SSD-75680468, Stoney Creek Battery Energy Storage System, 41 Stoney Creek Road, Narrabri; Response to Environmental Impact Statement

Transport for NSW (TfNSW) is responding to Stoney Creek Battery Energy Storage System (BESS), exhibited from 20 November 2025 and referred via the Major Projects Portal.

TfNSW has reviewed the Environmental Impact Statement (EIS) prepared by SLR Consulting, dated 30 October 2025, and the Traffic Impact Assessment (TIA) prepared by SLR Consulting, dated 21 October 2025, as key documents for preparing this response.

SWEPT PATH ANALYSIS - PRIMER MOVER FOR TRANSFORMER (31m LENGTH) - ENTERING SITE ACCESS 1

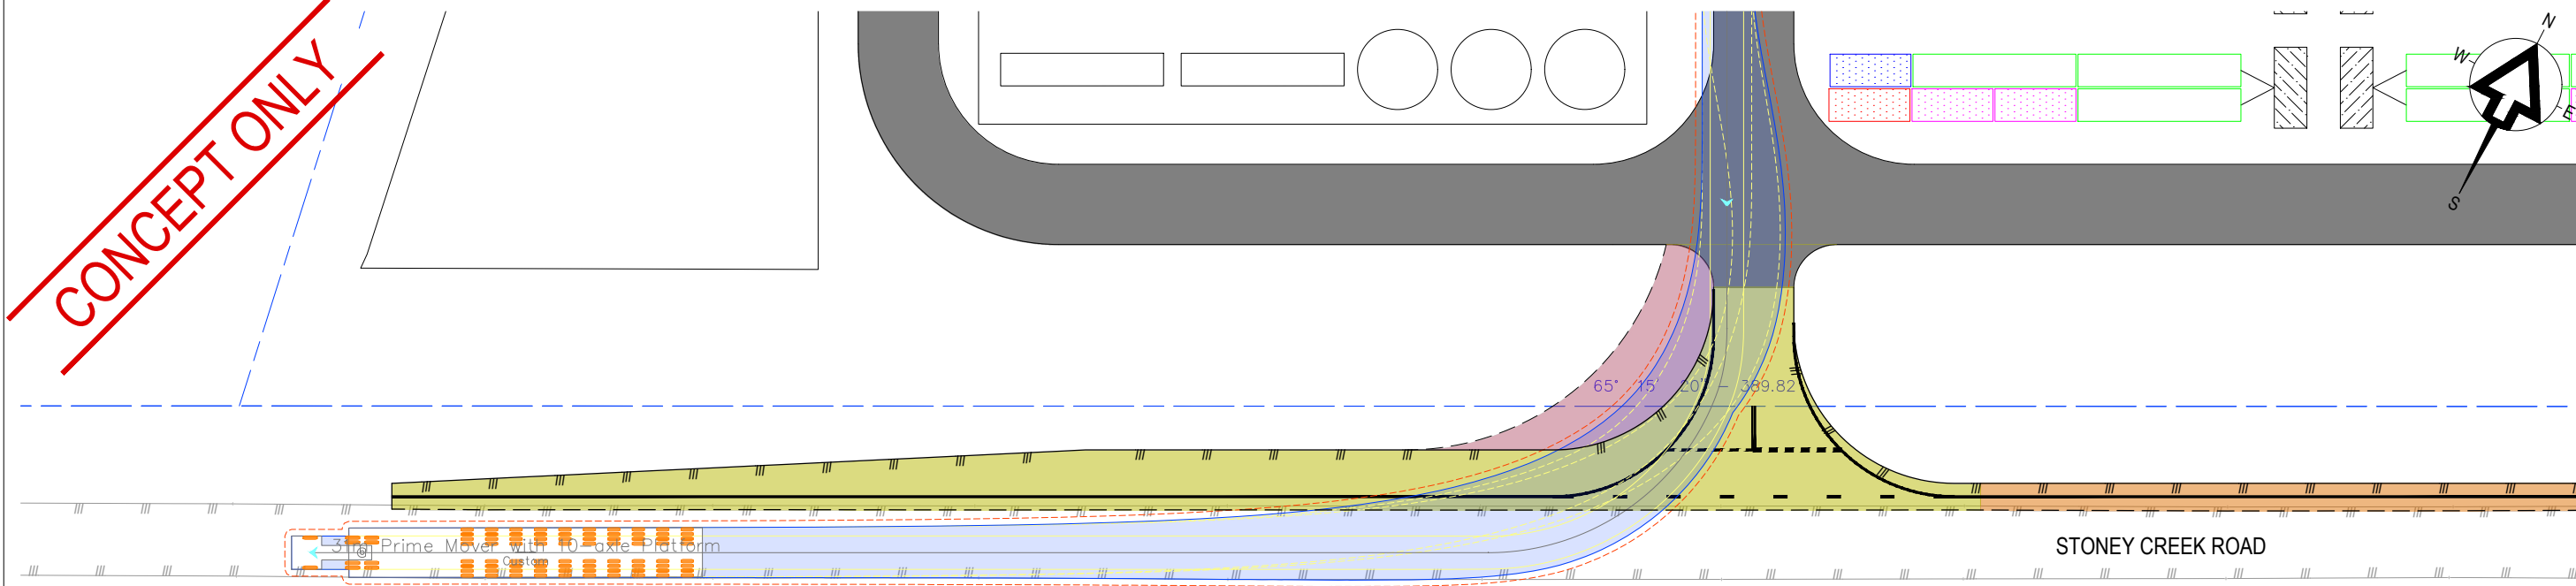
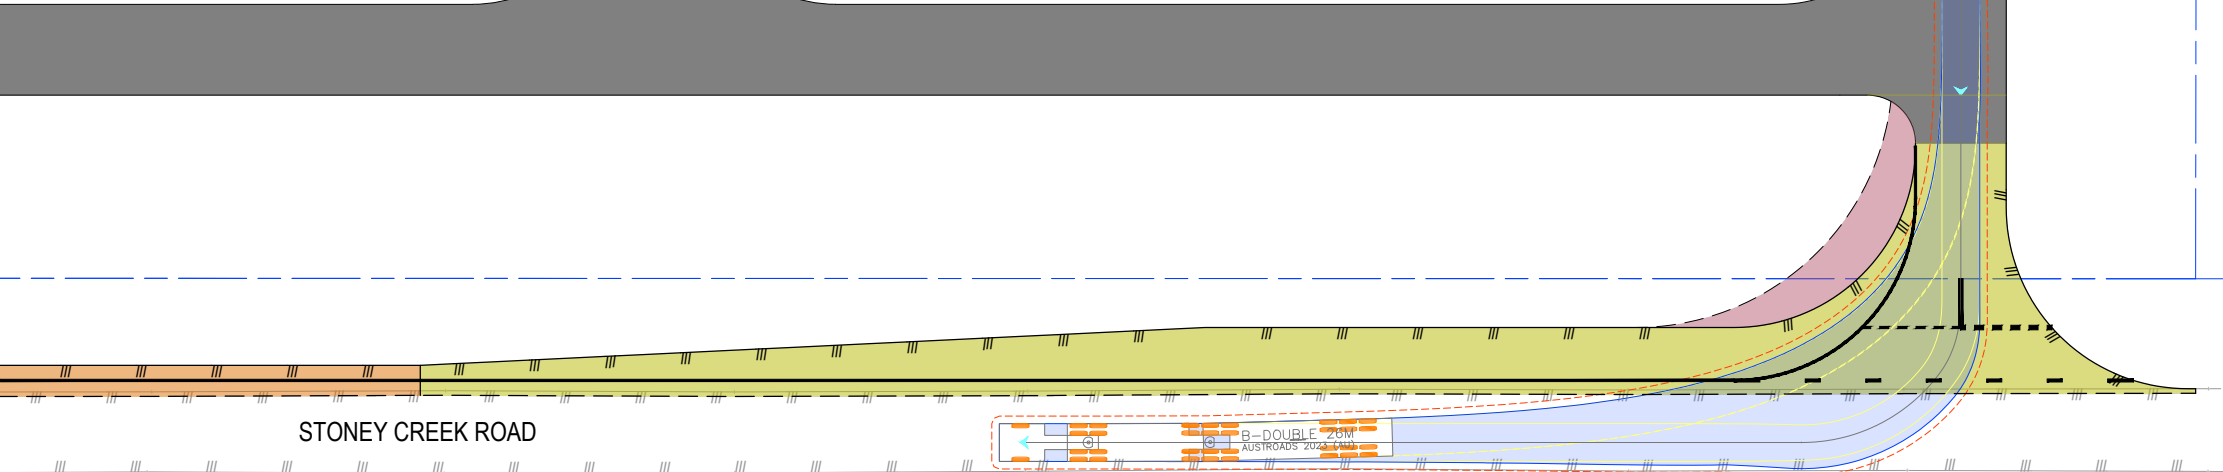
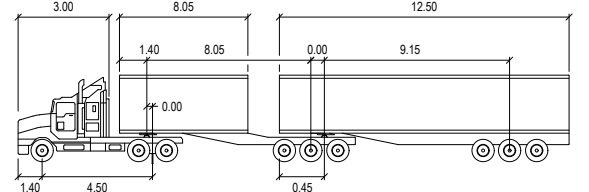
- a) The revised TIA must include a comprehensive OSOM route analysis from origin to site, which addresses the requirements stated in Attachment B, including swept paths for all pinch points along the State road network.
- b) The number of high-risk OSOM trips and respective routes is to be clarified in the revised TIA.
